MECKLENBURG COUNTY
Land Use & Environmental Services Agency

To: Charlotte-Mecklenburg Planning Commission
From: Dylan J. Kirk, Mecklenburg County LUESA
Date: January 21, 2021
Subject: Initial Rezoning Petition Comments

2020-194: Toomey Avenue, LLC

SHEET
REZONING PLAN
RZ.01

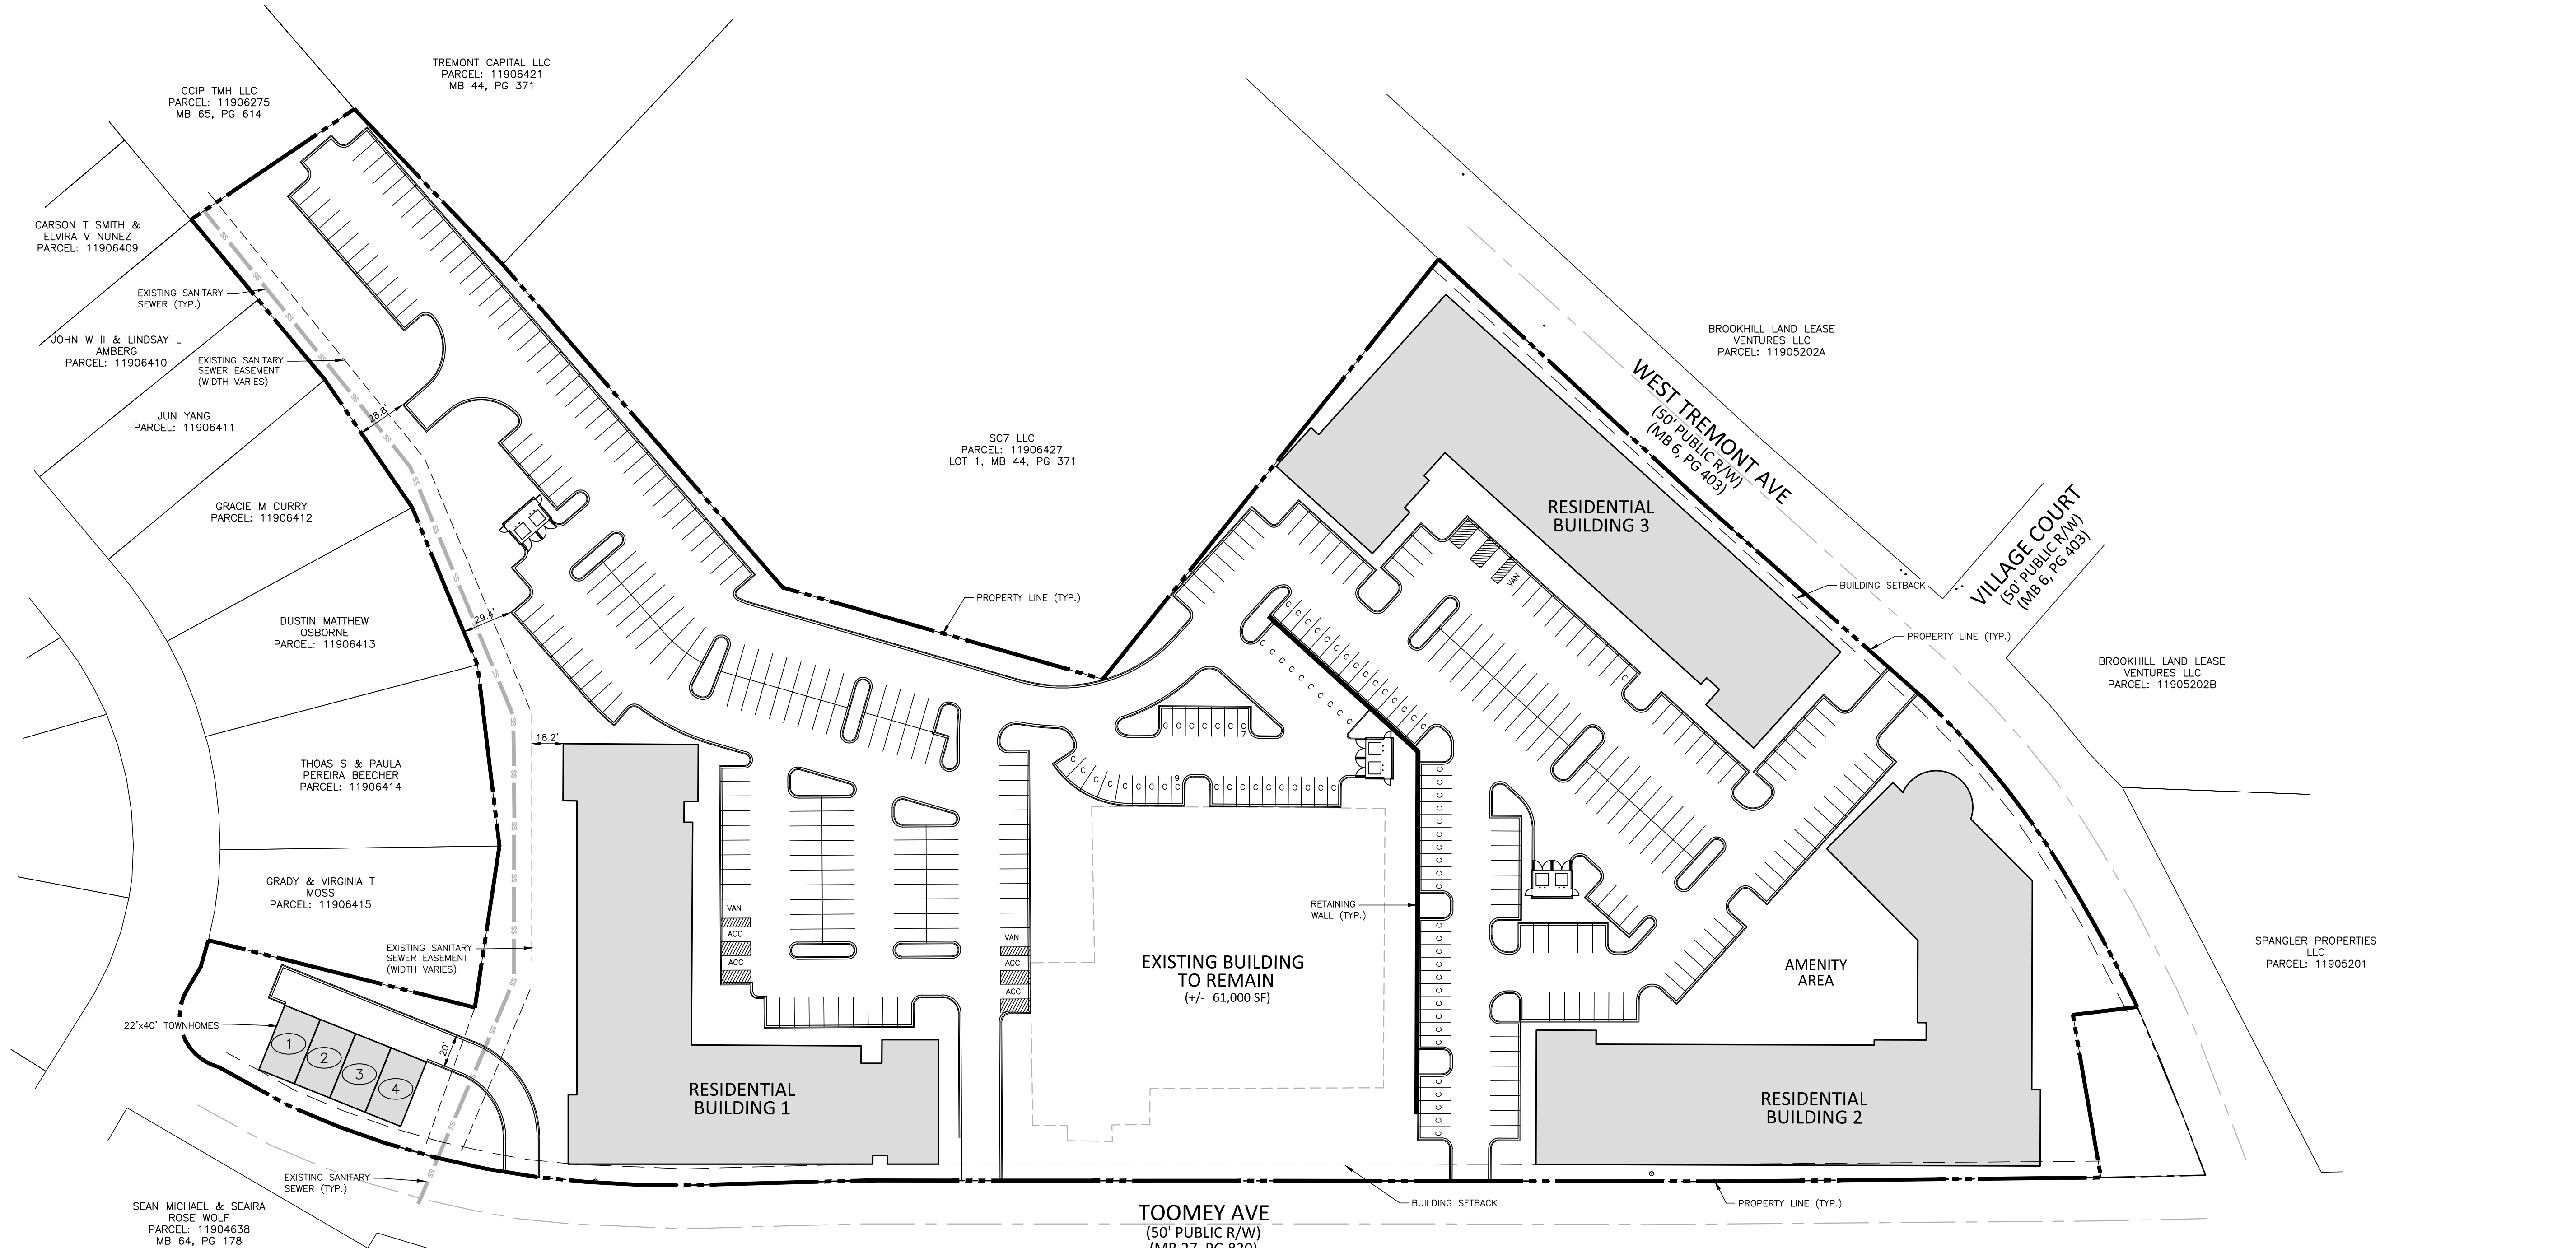
A water supply well is registered as an inactive irrigation well on parcel 119-064-17. GWS records do not indicate that these water supply wells have been permanently abandoned.

GWS recommends that the petitioner identify any water supply wells within the project boundary and either protect the wells from damage by flagging and fencing during site development or permanently abandon the wells per the Mecklenburg County Groundwater Well Regulations prior to any demolition or grading activity occurring and conduct survey to locate the septic systems. A permit from GWS is required for permanent well abandonments. The abandonments must be completed by a North Carolina Certified Well Contractor.

Subsurface Investigation Permit (SIP) 50000600 was issued for Parcel 119-064-28. Four monitoring wells are registered to this SIP. Subsurface Investigation Permit (SIP) 70001186 was issued for Parcel 119-064-17. No monitoring wells are registered.

If any MWs are identified within the project boundary GWS recommends that the petitioner either protect the wells from damage by flagging and fencing during site development or permanently abandon the wells per the Mecklenburg County Groundwater Well Regulations prior to any demolition or grading activity occurring and conduct survey to locate the monitoring wells. A current SIP from GWS is required for permanent well abandonments. The abandonments must be completed by a North Carolina Certified Well Contractor.

Review of the North Carolina Department of Environmental Quality (NCDEQ) Division of Waste Management database shows that Parcel 119-064-28 is included in Brownfield Project Number 02002-98-060, Dynatech Brownfield and Parcel 119-064-20 is included in Brownfield Project Number 25001-21-060, Dynatech II Brownfield both with known soil and groundwater contamination. Parcels 119-064-24 and 119-064-28 are included in the "South Bv Groundwater Contamination Plume".

Any development on these parcels should comply with applicable NCDEQ requirements for management of this contamination site.
